Response to Submissions Report

State Significant Development – SSD-10291

St Luke's Grammar School – Senior School Campus and Sports Centre

210 Headland Road and 800 Pittwater Road, Dee Why and 224 Headland Road, North Curl Curl

DRAWING TITLE
 STAGE 2 DROP-OFF & PICK-UP AREA
 B99 VEHICLE & TOYOTA COASTER
 ADDRESS
 No.800 Pittwater Road,
 Dee Why

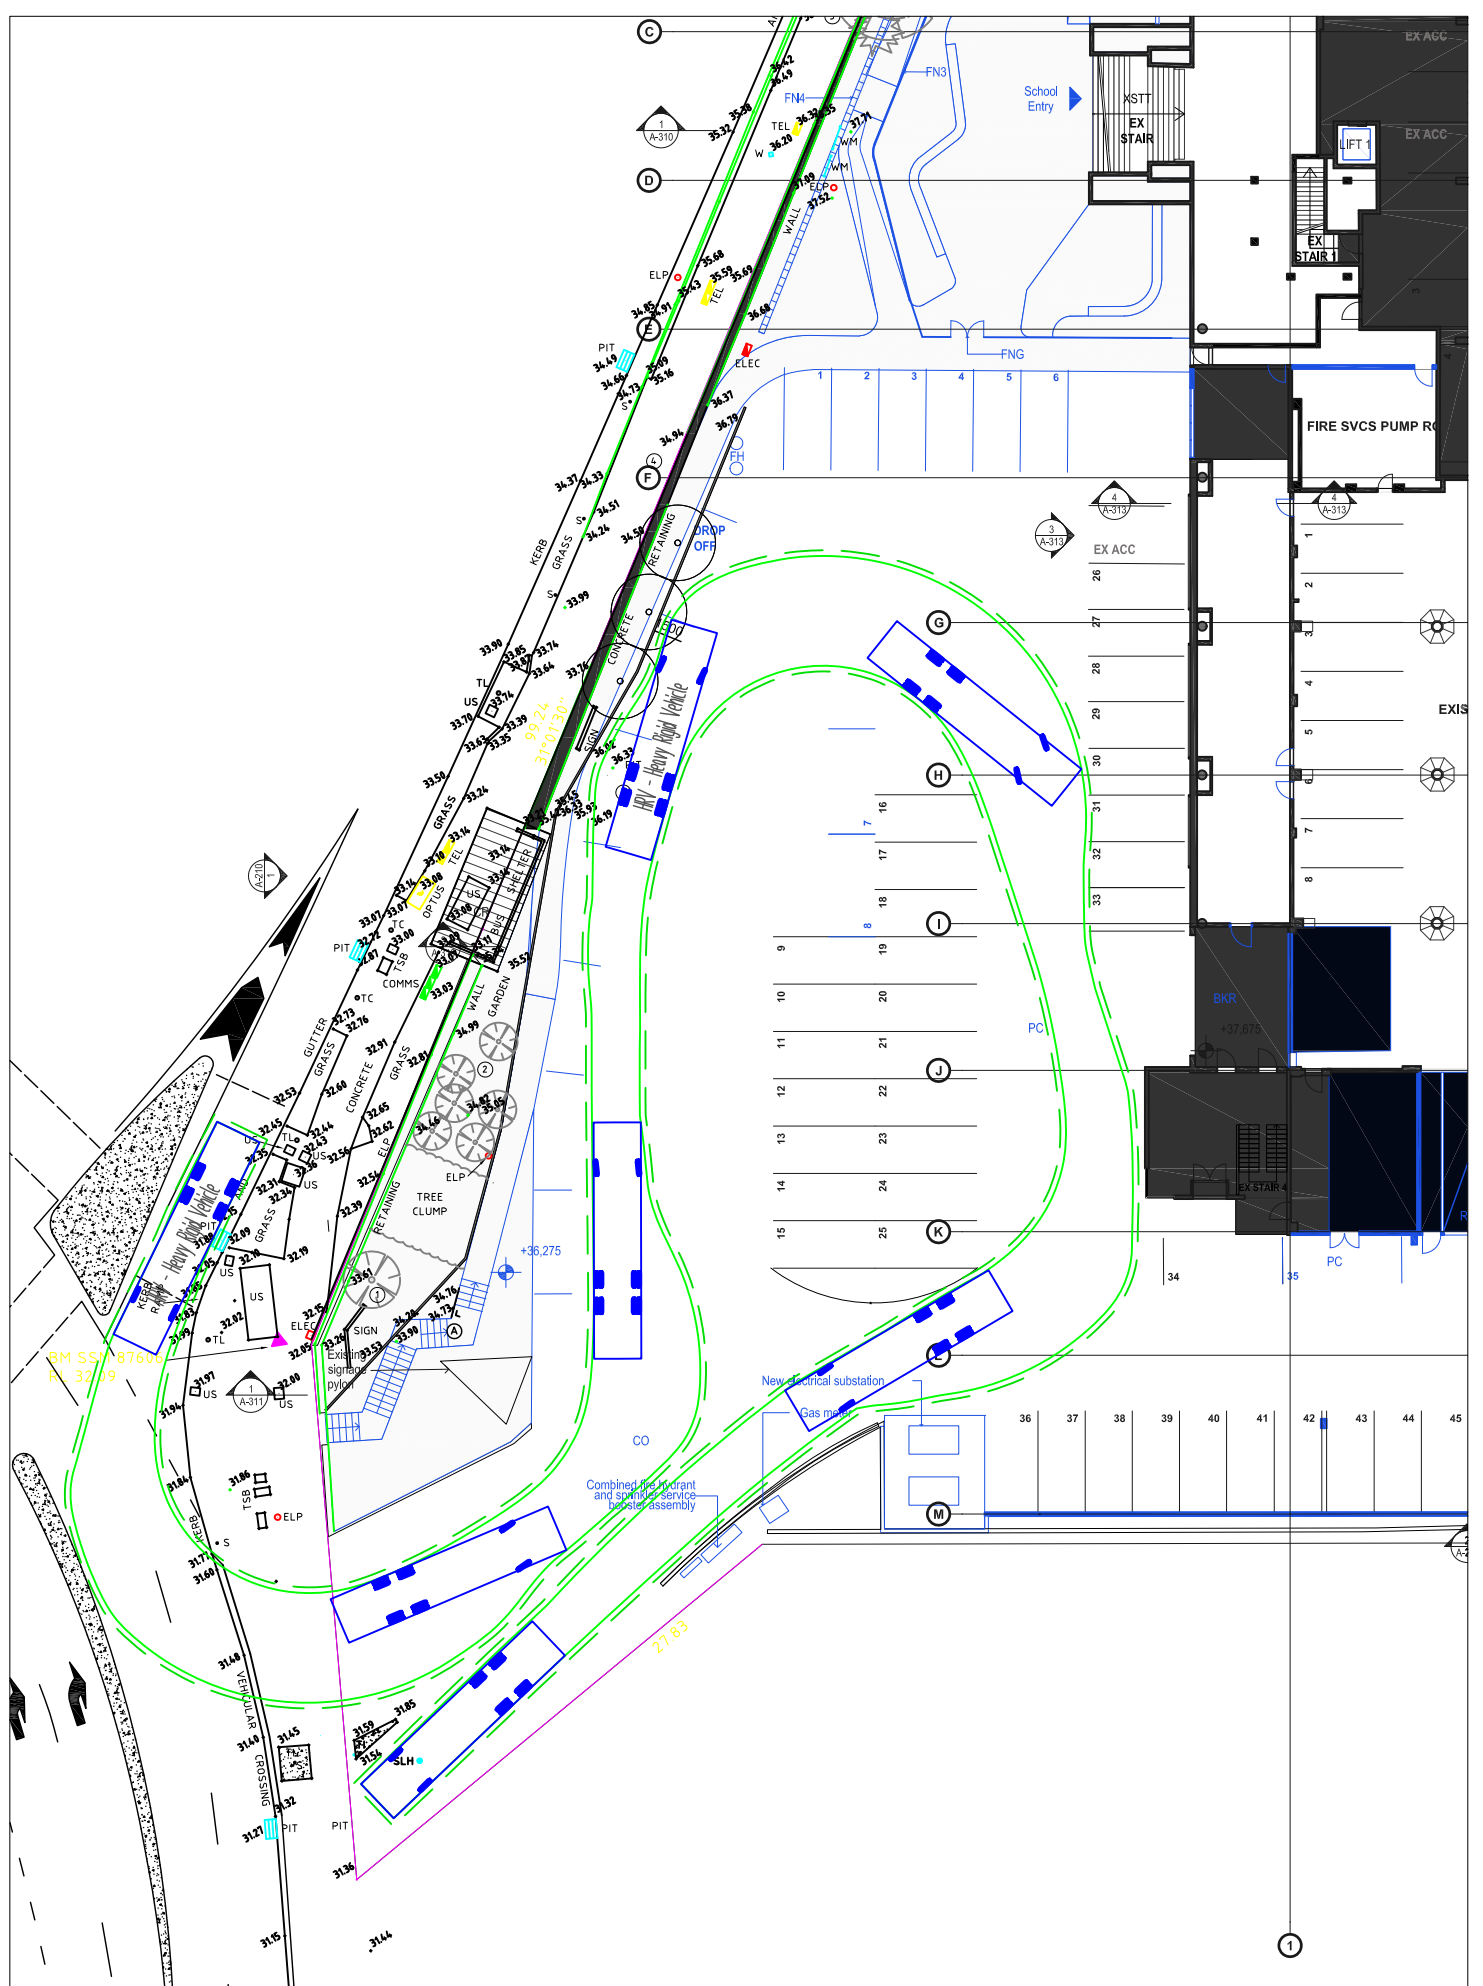
Item #	Issue	Response	Reference															
1.1	Traffic and parking impacts and assessment																	
1.1.1	<p>The Department notes that Transport for NSW (TfNSW) have raised concerns regarding the increase in pedestrian / vehicle conflicts associated with the Harbord Road driveway providing access to the senior school campus at 800 Pittwater Road. The Department agrees with the above concern. Noting the proposed change of use of the premises, the Department requires you to:</p> <ul style="list-style-type: none"> investigate the feasibility of an alternative access point to the site, including the closure of the Harbour Road driveway. Or 	<p>The following seven (7) alternative vehicular access points to 800 Pittwater Road were considered by the proponent (Figure 1 and Attachment 3):</p> <ul style="list-style-type: none"> Option 1: Existing driveway from Harbord Road; Option 2: New entry from Pittwater Road; Option 3: Vehicle entry via 224 Headland Road; Option 4: Vehicle access via Stony Range Regional Botanic Garden; Option 5: Vehicle access via 226 / 228 Headland Road; Option 6: Vehicle entry from 275 Harbord Road; and Option 7: Vehicle entry from 210 Headland Road (entry from Tango Avenue).  <p><i>Figure 1 Plan showing location of alternative entry points to 800 Pittwater Road, Dee Why (TZG)</i></p> <p>A review of each of the options for vehicular entry is provided below:</p>
